ENVIRONMENT PROTECTION AUTHORITY

Our reference : DOC16/308478
Contact: Ramya Gowda, epa.farwest@epa.nsw.gov.au

I refer to the Project Application, Environmental Assessment (EA) and accompanying information provided for the proposed Nyngan Scandium Project (ref SSD-5157) received by the Environment Protection Authority (EPA) on 25 May 2016.

Figure 2 The Proposed Site Layout

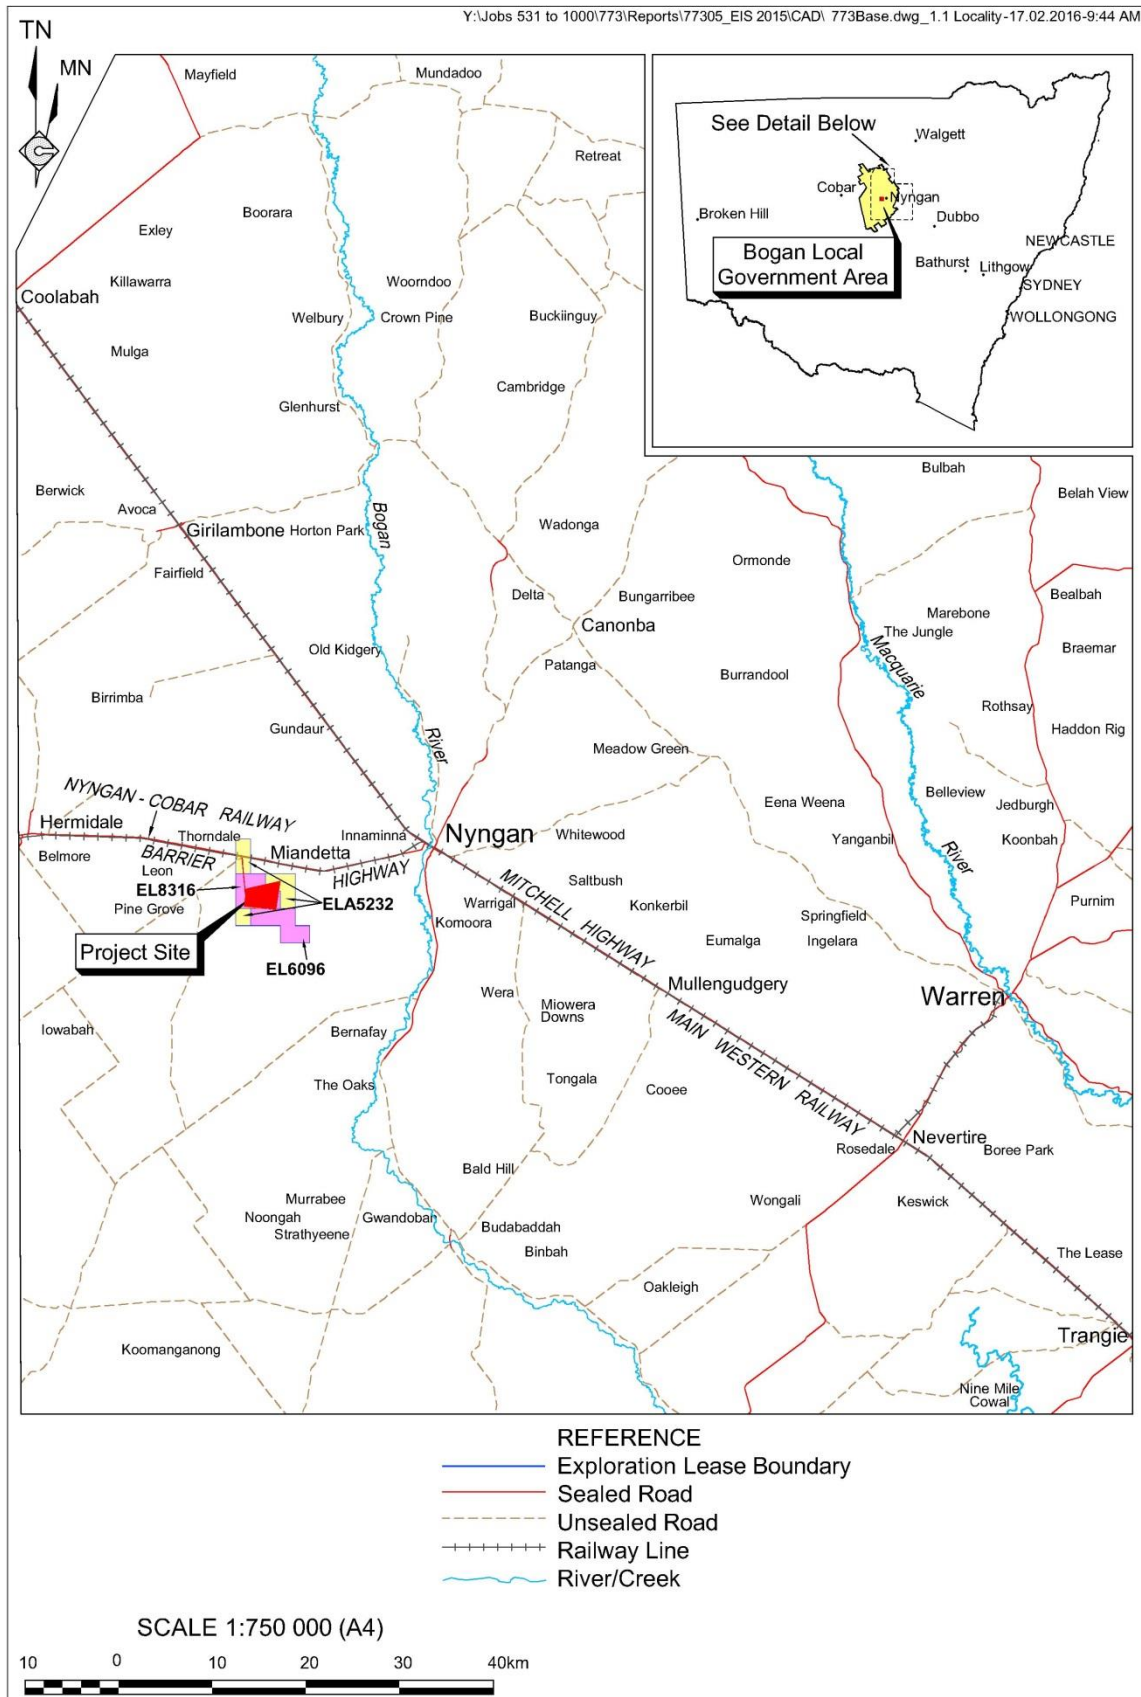
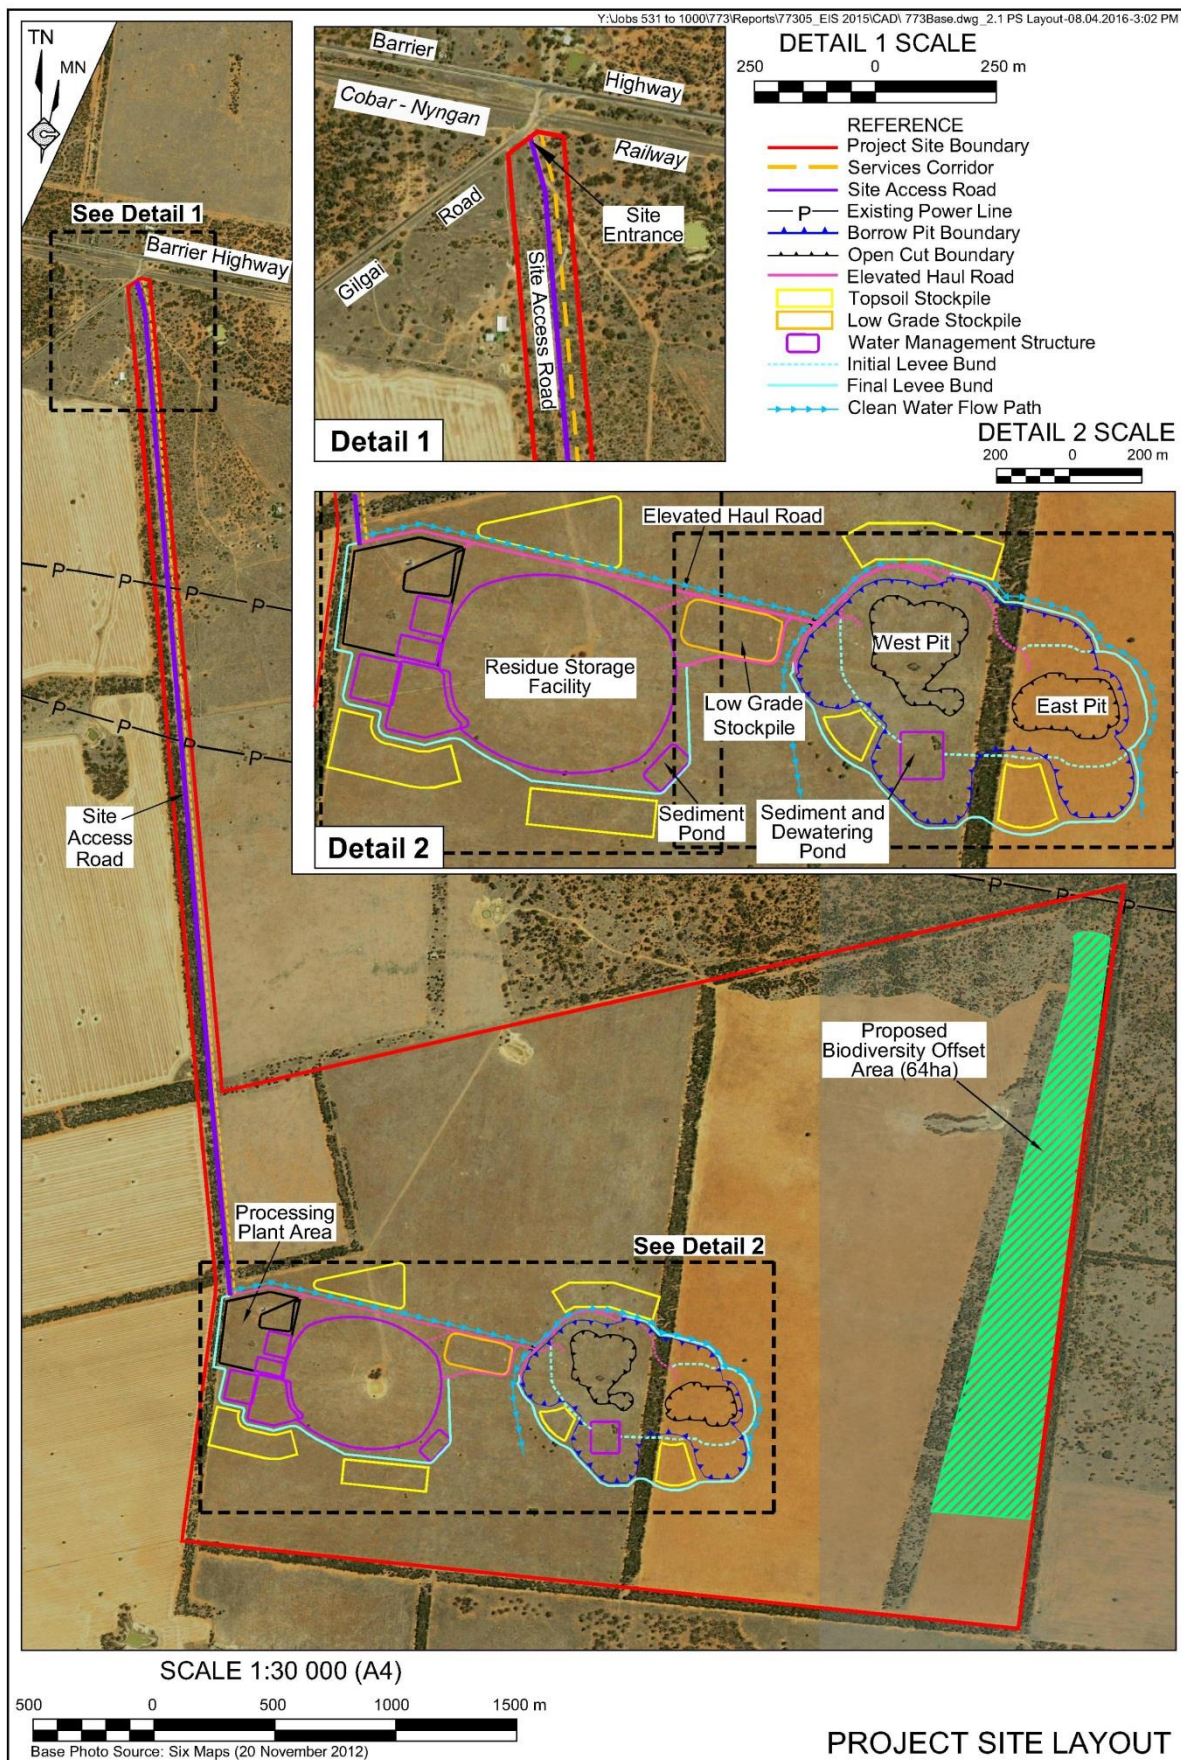
The proponent must assess the operational noise impact of the project's access road on sensitive receivers

Due to the distance between residences and the extraction, processing and storage areas of the site, the EPA expects that those parts of the project can comply with an operational noise limit of $L_{eq(15min)}$ 35 dBA at all residences. However the on-site access road is much closer to some residences.

The noise contour plots in Figure 6 and Figure 7, and the predicted noise levels in Table 5 of the noise assessment, do not seem to show an influence from the access road on operational noise levels.

Based on the sound power level in the noise impact assessment and the EPA's modelling, the EPA expects operational noise levels from the access road at the nearest sensitive receiver will be up to about $L_{eq(15min)}$ 42 dBA, which is 7 dBA above the project specific noise level. Those noise levels would need to be managed in accordance with the *Voluntary Land Acquisition and Mitigation Policy* (NSW Government 2014).

- noise from vehicles using the proposed access road, in accordance with the industrial noise policy; and
- noise from construction of the proposed access road, against chapters 8 and 9 of the industrial noise policy
